TOWN AND COUNTRY PLANNING ACT 1990 APPROVAL REQUIRED BY CONDITION OF PERMISSION

Reference:	H07-0118-24	Date of Decision:	26th April 2024
Applicant:	Mr A Zdroba 32 Hillgate Gedney Hill Spalding Lincolnshire PE12 0NN		
Location:	32 Hillgate Gedney Hill Spalding Lincolnshire		
Description:	Details of first floor window in southern side elevation serving obscure glazing, additional tree planting & surface water disposal (Conditions 3, 4 & 6 of H07-0987-22)

Rev A 04/11/20 Landscaping added
Project:
Detached Garage
Client:
Rebeca Zdroba
Address:
32 Hillgate
Gedney Hill
Spalding
PE12 ONN
Drawing Title:
Site Plan
Drq No: 03
Scale: 1:500 @ A3
Date: Mar 2020

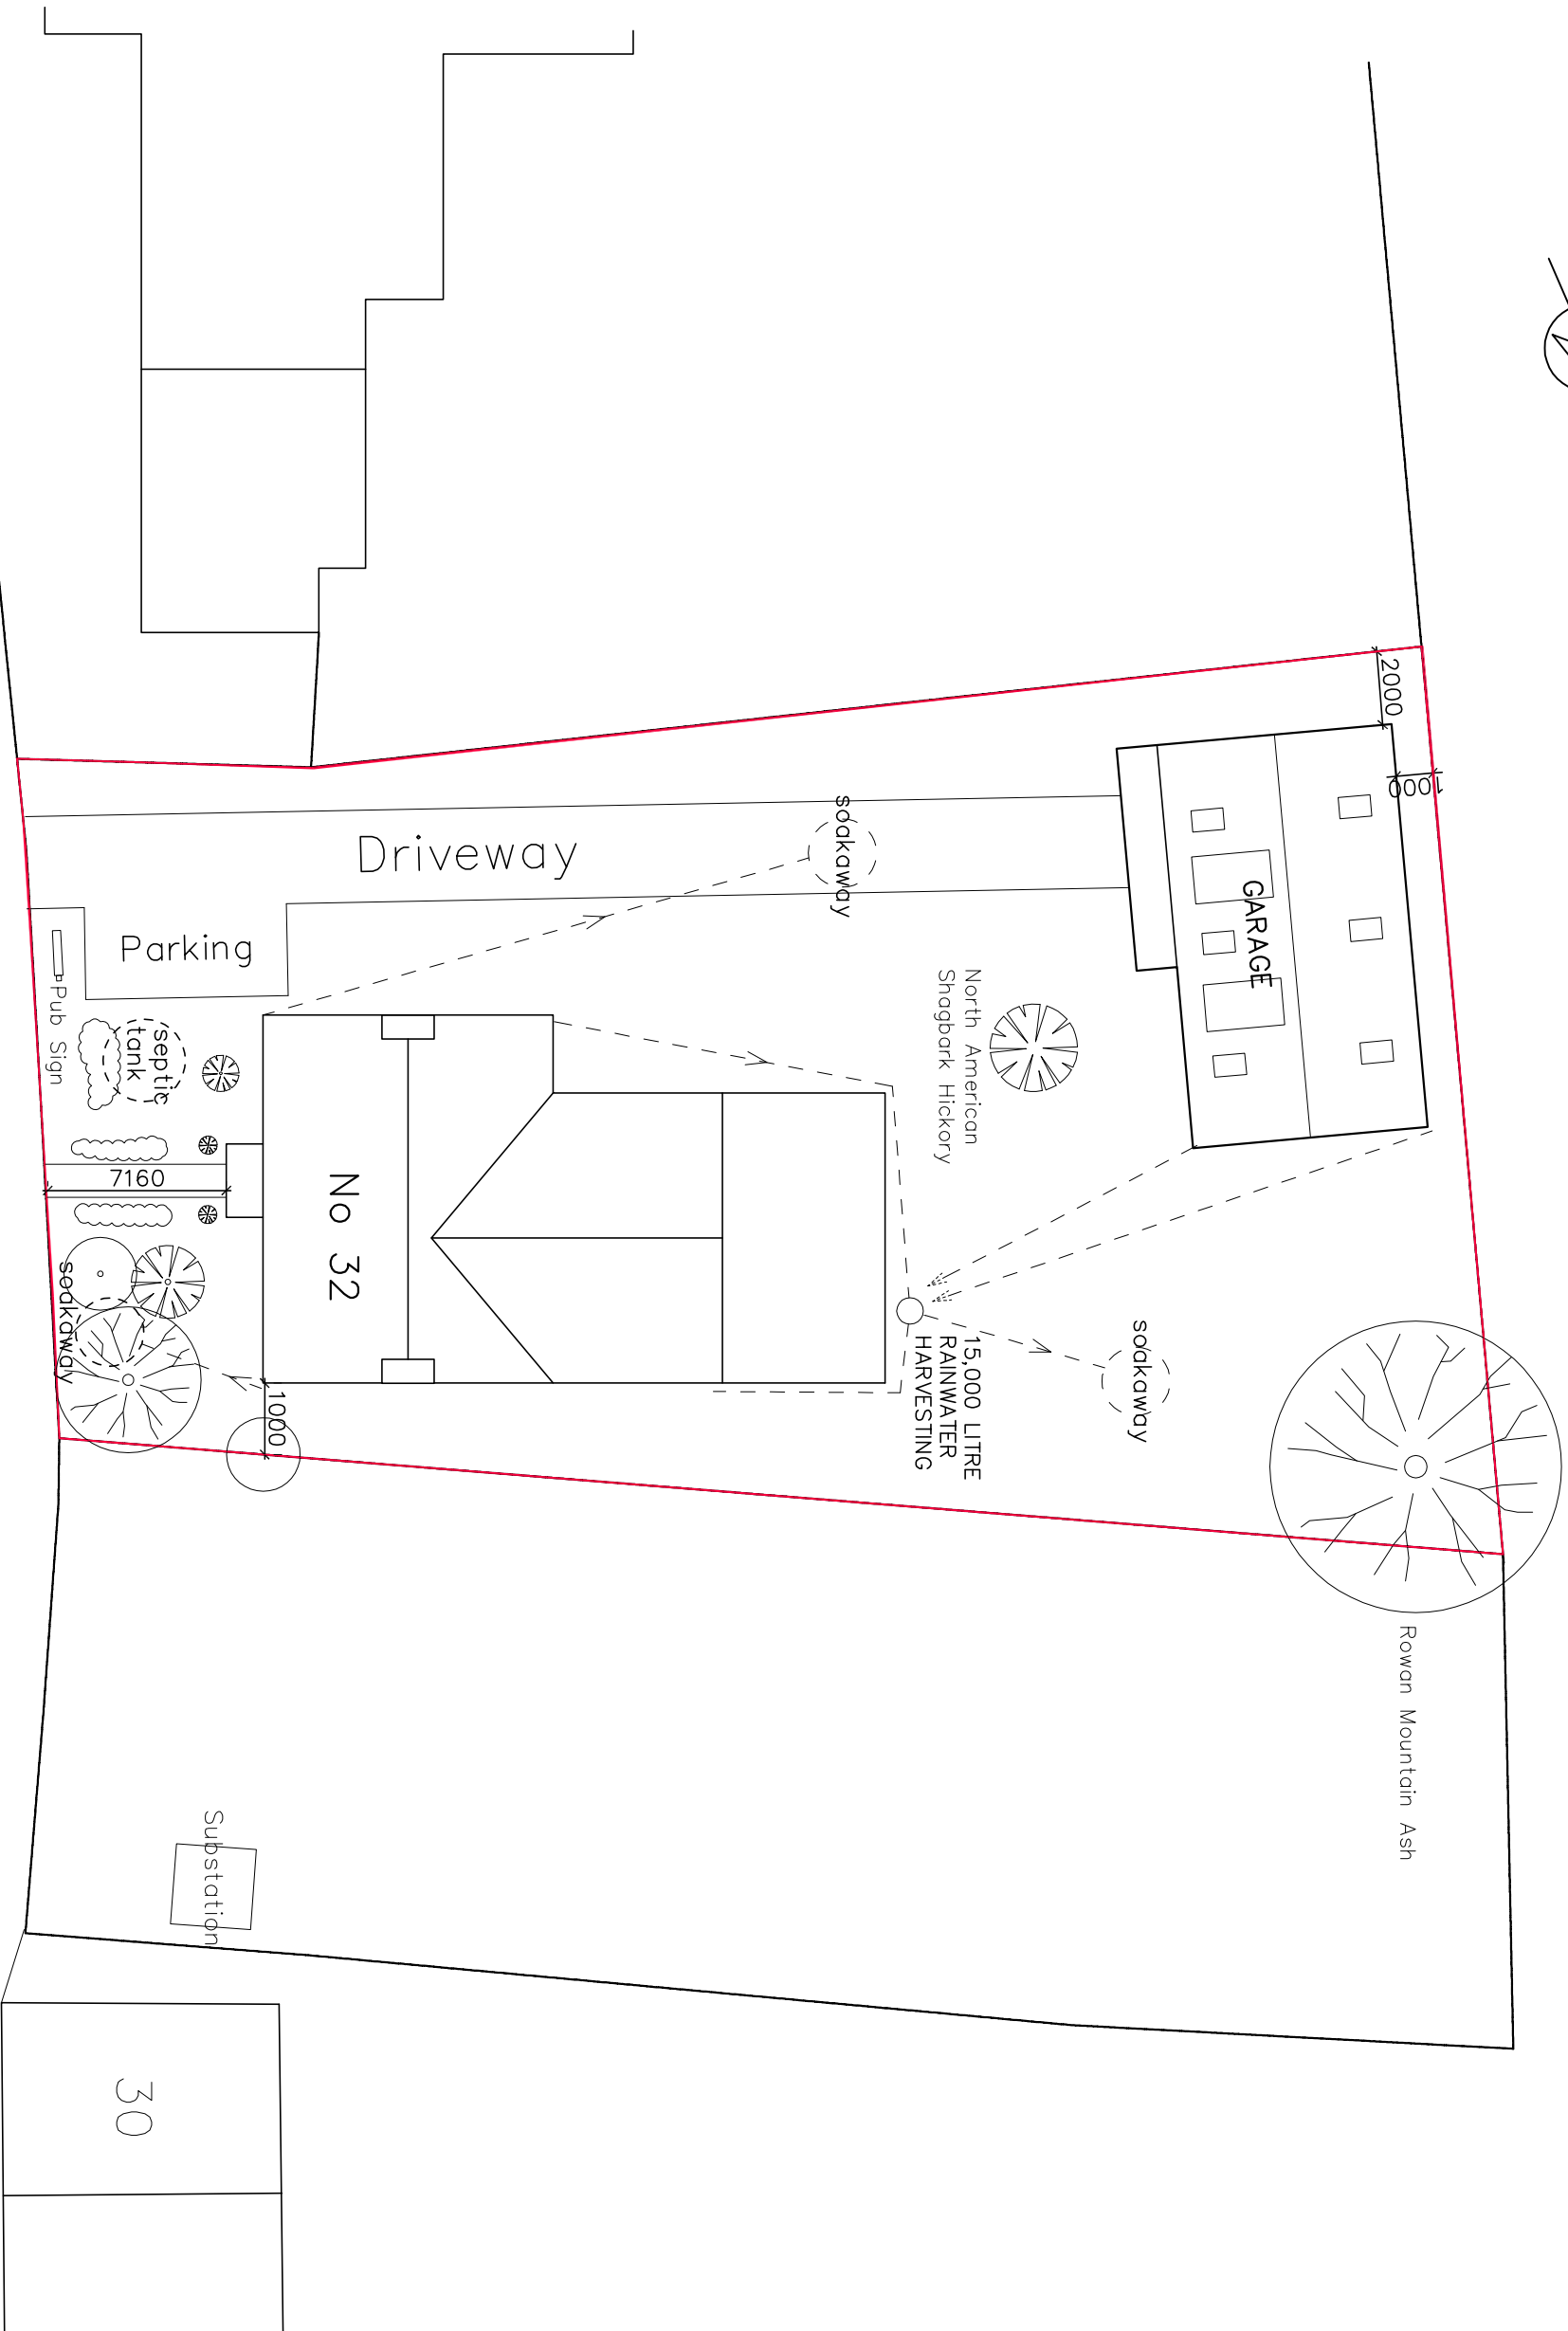
- 1 In the opinion of the Local Planning Authority the information submitted does not satisfactorily demonstrate that the proposed rainwater system is viable without increasing flood risk on or adjacent to the site. Consequently, Condition 6 of H07-0987-22 cannot presently be discharged.

The submitted details appear to indicate that there would be some infiltration of surface water within the plot. In which case, your attention is drawn to the need to comply with the requirements of the South Holland Internal Drainage Board within their letter dated 10

April 2024 accompanying the application. Essentially, condition 6 cannot be discharged until details of an infiltration test have been submitted along with a calculation of the size of the soakaway(s) or drainage field/infrastructure required as a result. Written consent will also be required to confirm the neighbour's agreement to the laying of the outfall pipe over their land.
